Recommendation Report for Planning Permission for Works or Extension to a Dwelling

REF NO: BR/33/26/HH

LOCATION: 29 Victoria Road
Bognor Regis
PO21 2JE

PROPOSAL: Loft extension involving raising of ridge height, hip to gable roof and construction of rear dormer along with installation of skylights on the front roof slope.

**Drawing Description:**  
Proposed Elevations

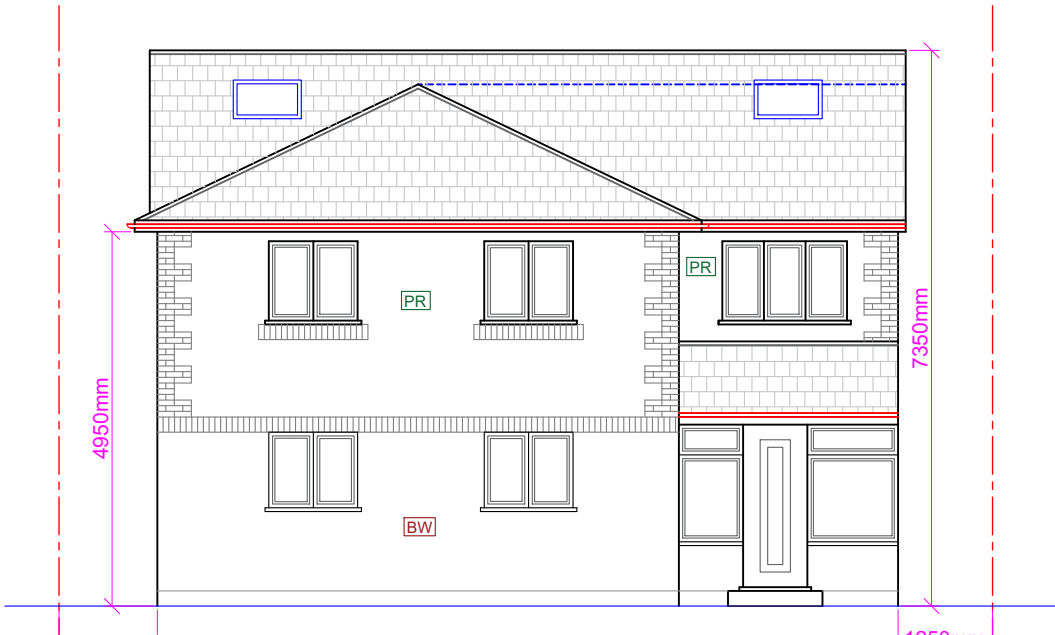
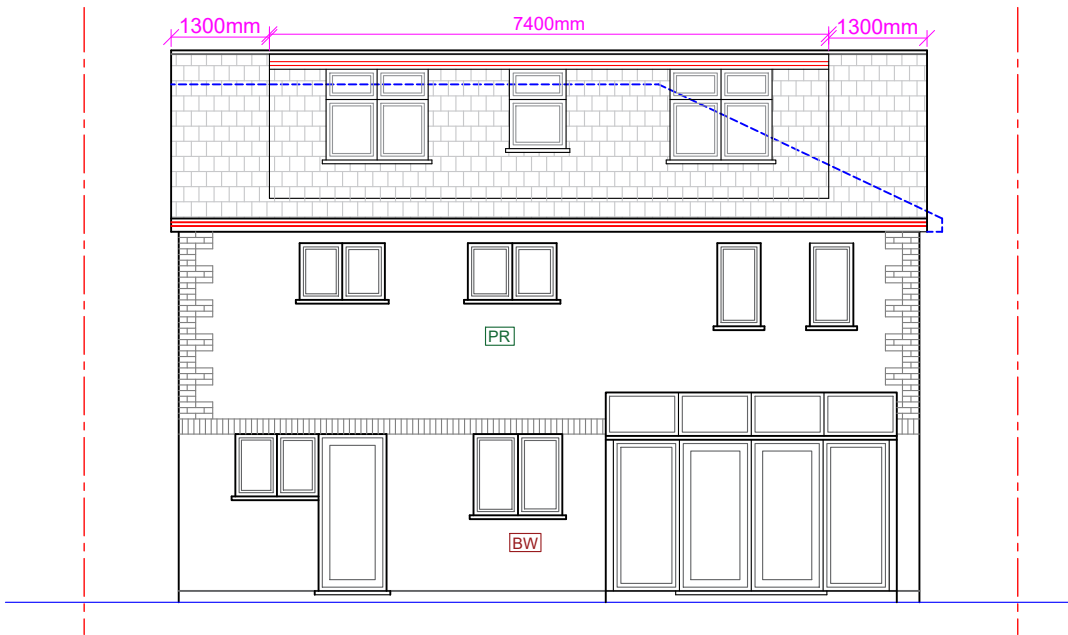
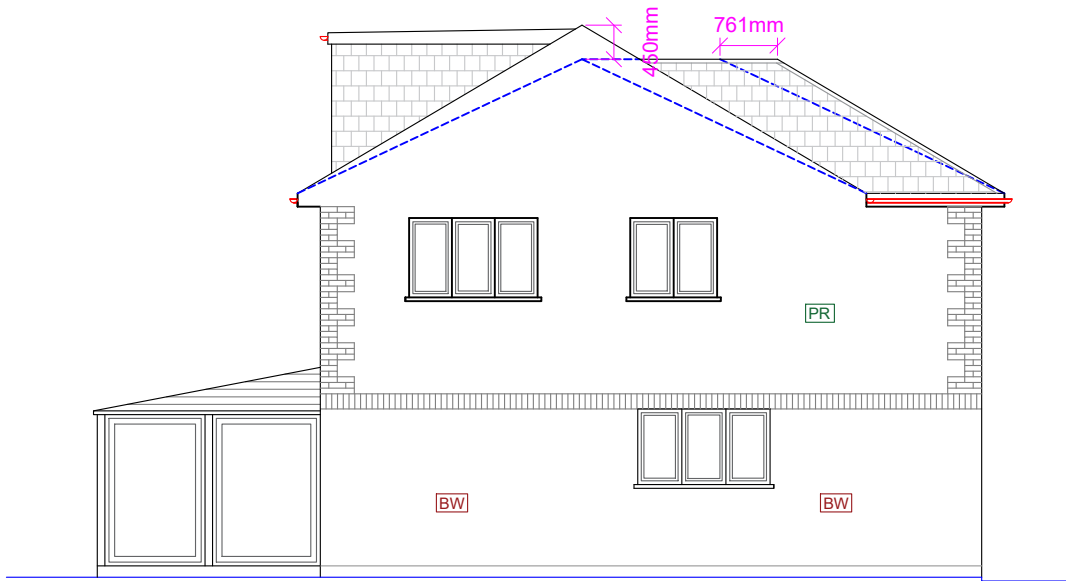
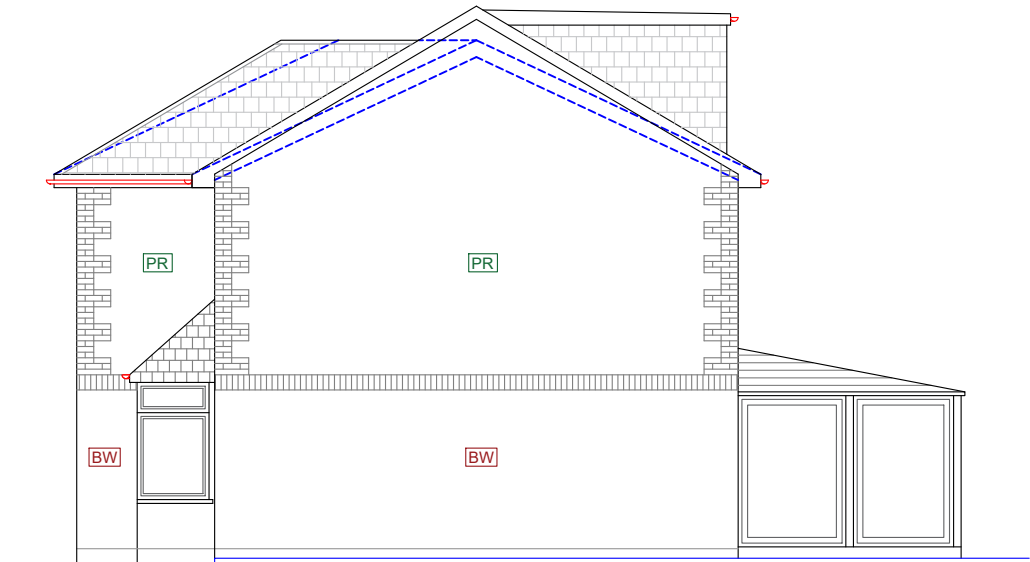
The proposal would involve extending the roof to the south by approximately 3.5m to create a hip-to-gable roof form. The overall ridge height would be increased from approximately 6.9m to 7.3m. This alteration would be visible from the public realm and would result in an increase in the massing and bulk of the roof. However, the character of the street is varied in terms of building height and roof forms, with the neighbouring dwelling to the north being of a comparable height to that proposed and further examples of three-storey buildings are present within the surrounding area. In addition, the proposed hip-to-gable form would mirror the existing roof arrangement on the northern elevation, resulting in a balanced and symmetrical appearance. Therefore, the proposed roof alterations would not result in harm to the character or appearance of the host dwelling, the street scene or the wider area.

A dormer is proposed within the rear roof slope, measuring approximately 7.4m in width and 3.2m in depth, with a flat roof and a maximum height of approximately 1.9m. The dormer would be finished in roof tiles to match those of the existing dwelling, ensuring visual integration in line with the Arun Design Guide (ADG). The dormer would contain two pairs of two-pane windows and a single one-pane window, in a style consistent with the existing fenestration. Two rooflights are also proposed within the front (east) roof slope.

Due to its scale and flat roof form, the dormer would not appear as a subservient addition nor a minor incident within the rear roof slope, contrary to guidance within the ADG. The increased bulk and flat roof design would appear visually dominant and would not reflect the character of the original dwelling. Nevertheless, its position to the rear of the dwelling would ensure that the dormer would not be a prominent addition within the street scene, and the use of matching materials would further reduce its visual impact. It is also noted that the surrounding area is varied, with large flat roof forms over two and three storey development and dormers visible within the street scene and neighbouring street scenes. As such, the given the siting of the proposed dormer and the wider context surrounding the application site, the proposed dormer would not result in demonstrable harm to visual amenity.
